Access Arrangements

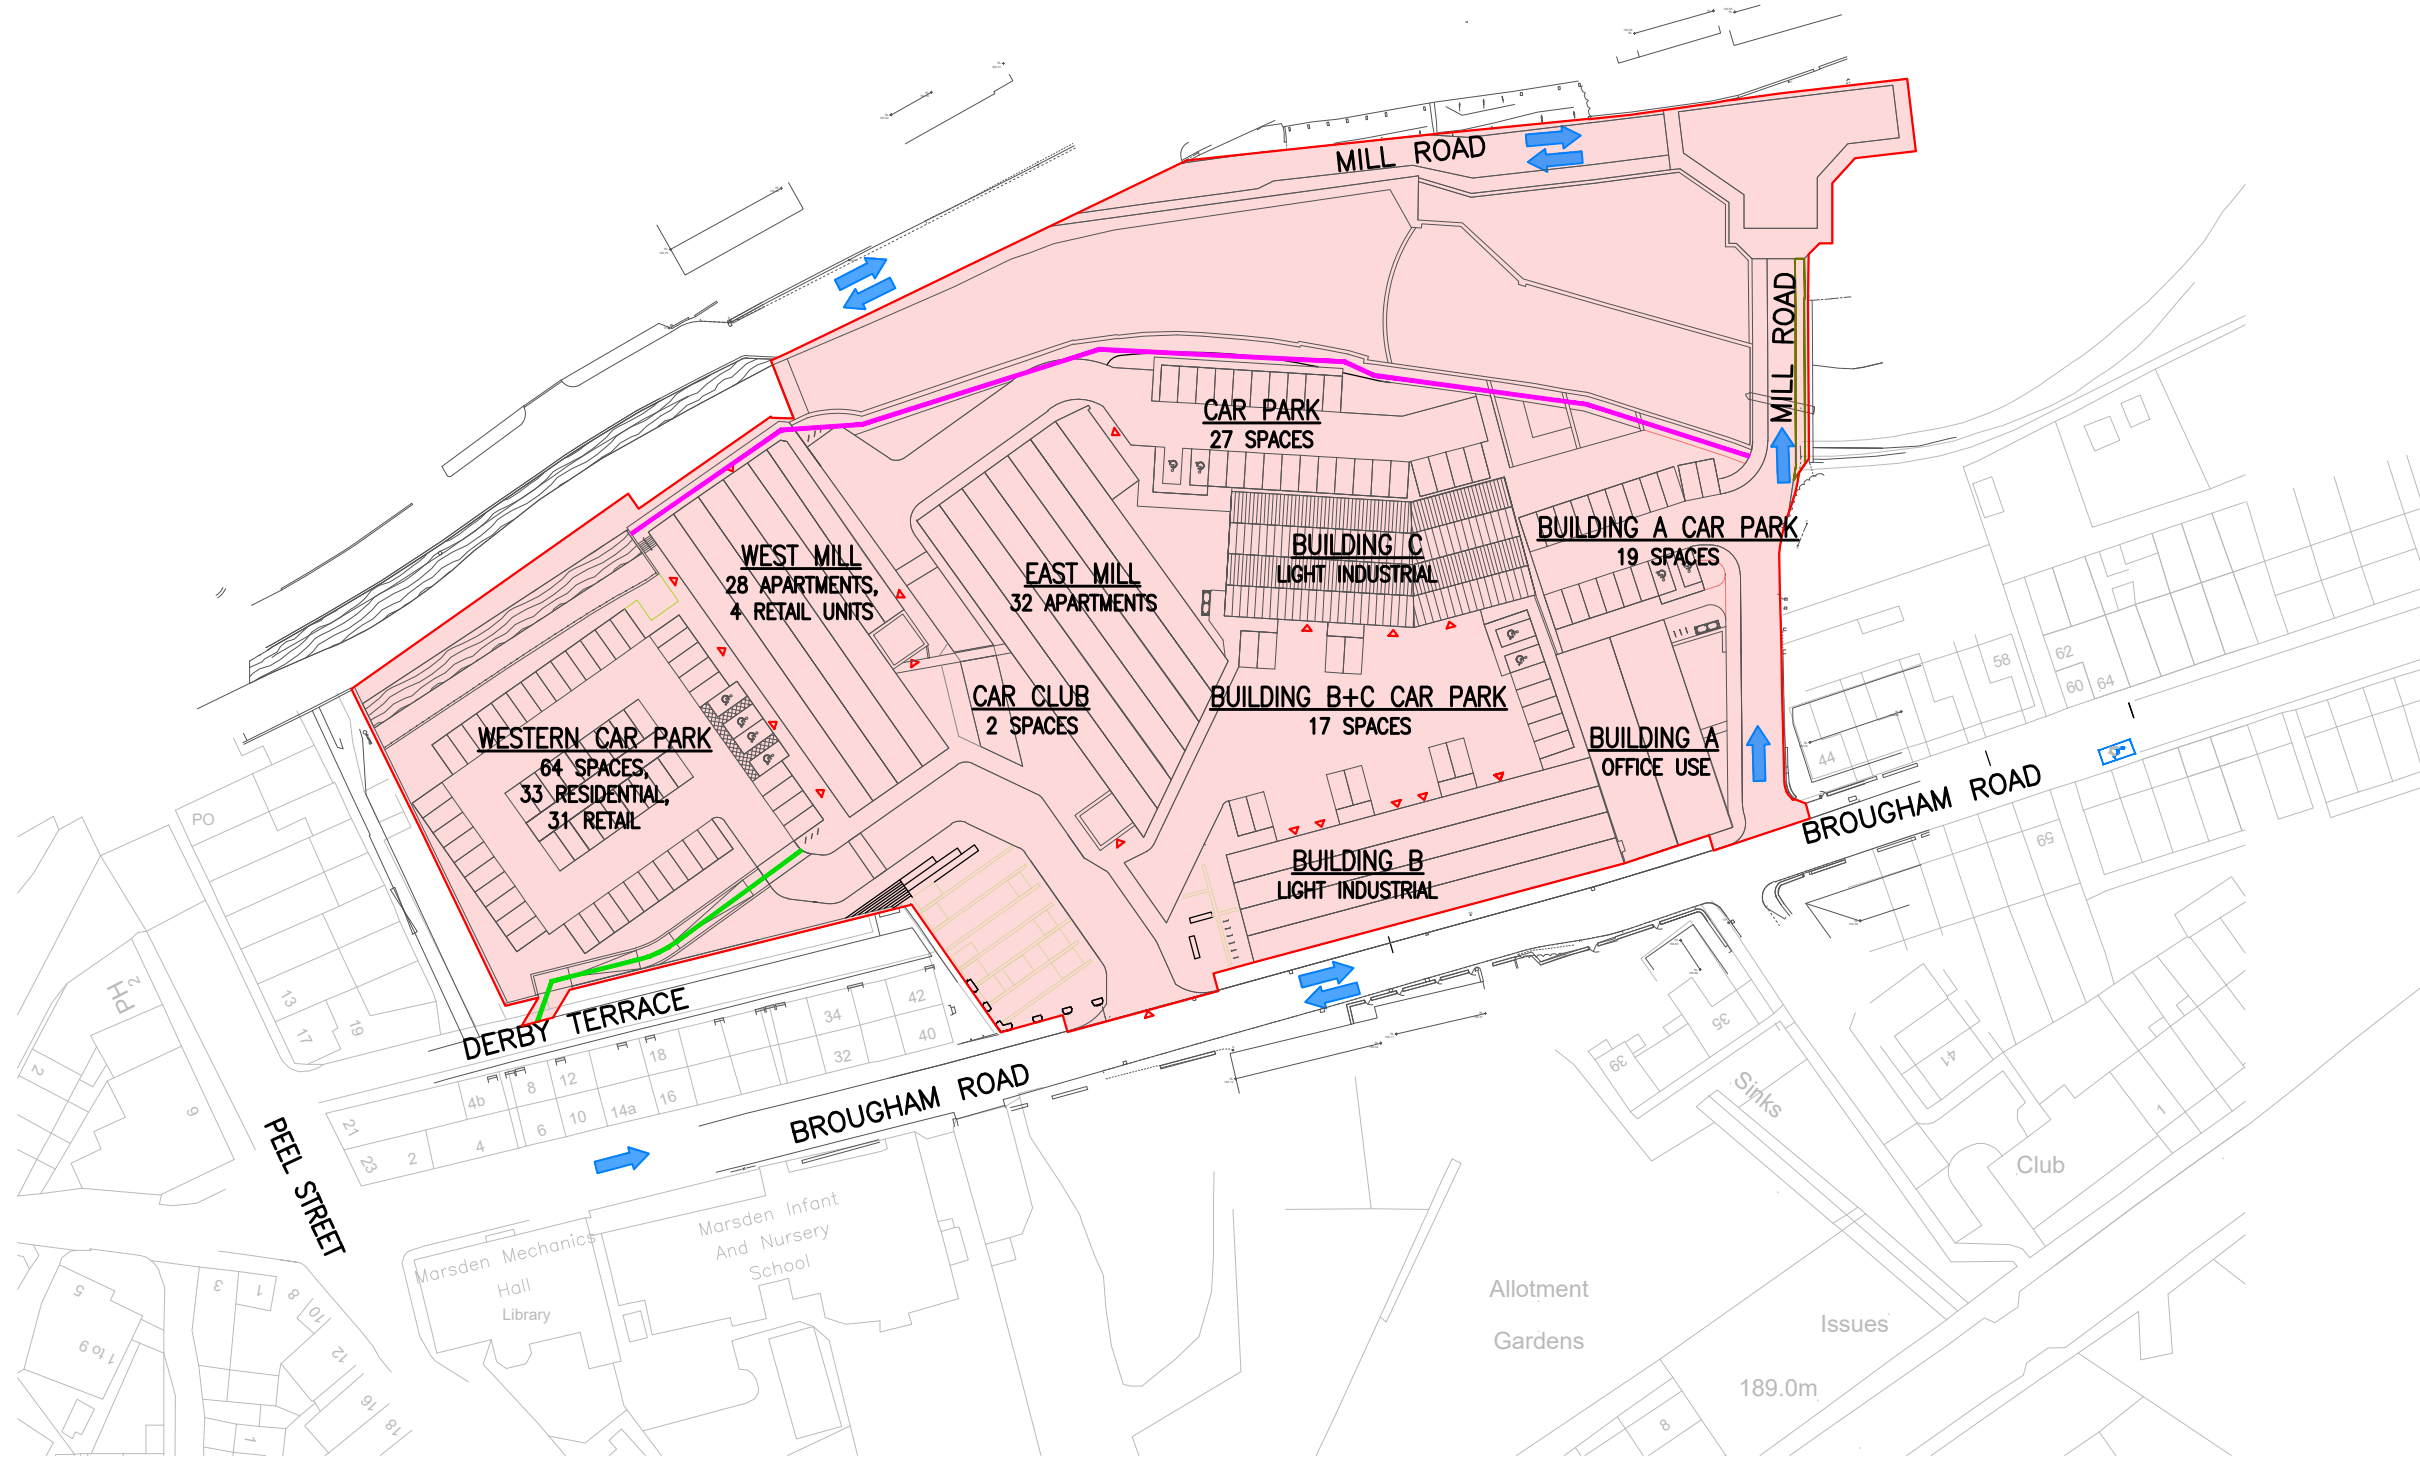
- The car club provision should be available for all Marsden residents, not just those living or working at New Mills.
- The pedestrian/cycle bridge to Warehouse Hill should be included in this planning application to make a direct link for those living in the Grange and Dirker areas and those joining from the canal towpath, even if further funding is required to build it. This will help encourage active journeys through the site (to school, new Co-op etc) rather than driving, and deter unnecessary traffic circulating through the village centre. The mill design should ensure it is fully future-proofed so it is as easy and cheap as possible to add a bridge in the future without requiring significant infrastructure works or any utilities at both ends. The bridge should be designed now to ensure this is possible as it interfaces the highway. Wheeling circulation from the bridge into the development should then be seamless.

Off Site Highway Improvements

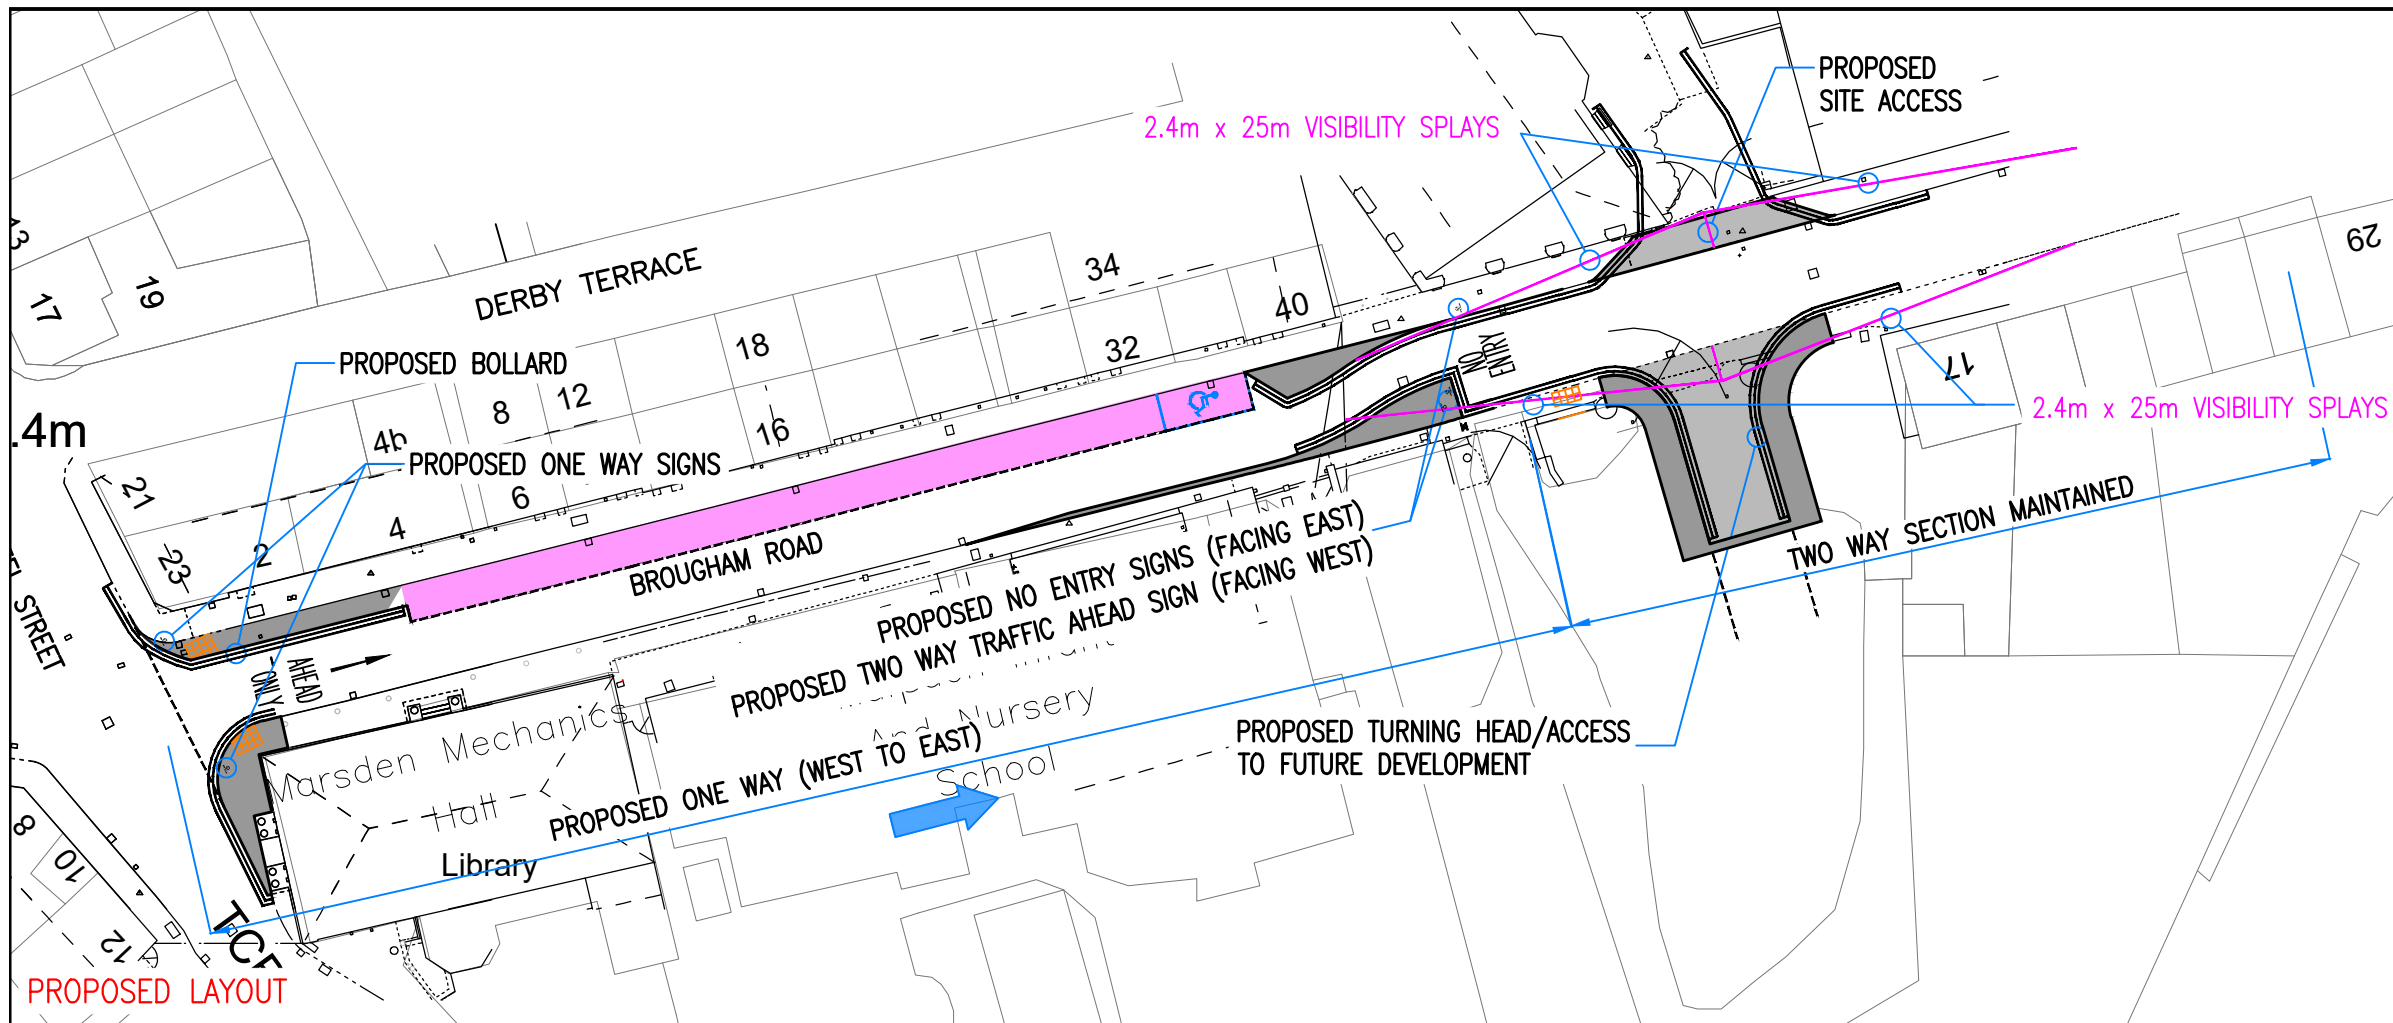
- The new footway on Mill Road is great, however off-site highways works need to extend this footway from Mill Road along Warehouse Hill Road to Peel St/Station Rd junction in order to provide a continuous facility for the safety of pedestrians. This is because the development will result in more vehicles on this road where people have to walk in the road with pushchairs, children etc to get to the village centre. Traffic calming or priority in certain sections, may be required to fit in this footway.
